## **PLAN REVIEW SHEET**

**Date: June 23, 2023**

**Petition #: 2023-027**

TECHNICAL DATA SHEET

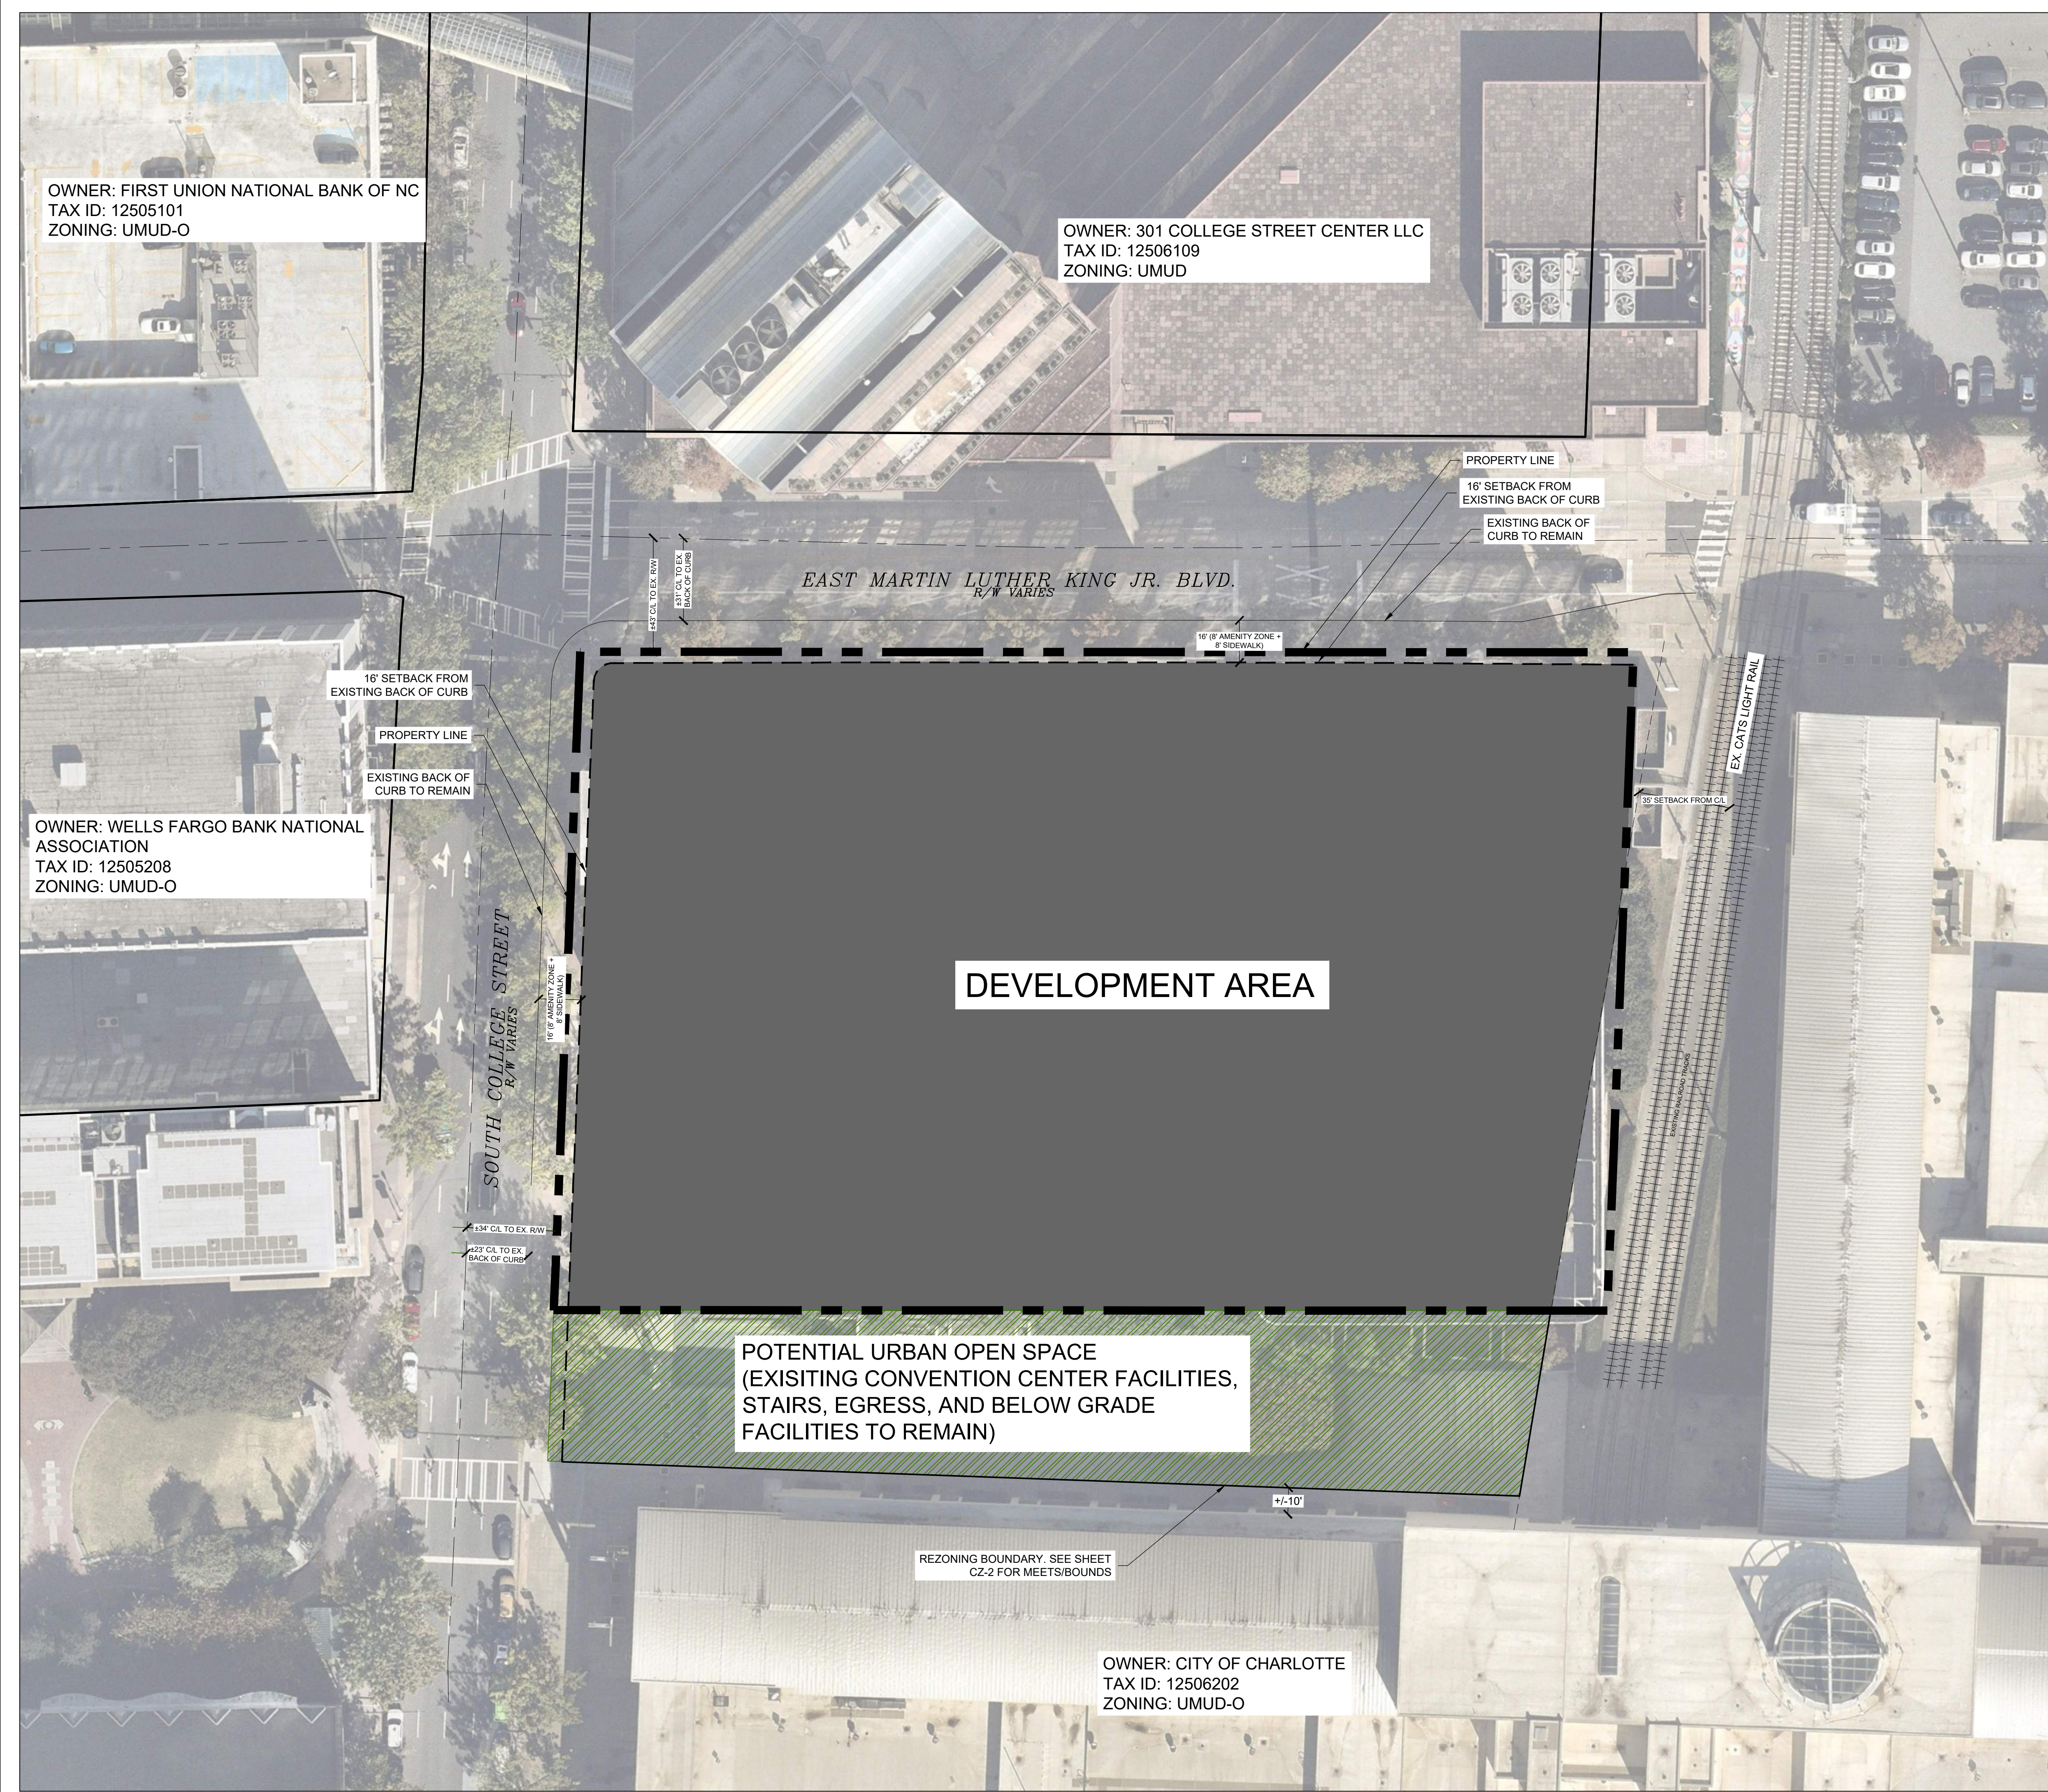
Bus: CATS requests the reservation space of a minimum 5'x8' for a future bus stop within the pedestrian amenity zone on South College Street. The final location will be coordinated with the developer and Charlotte DOT (CDOT) during the permitting process.
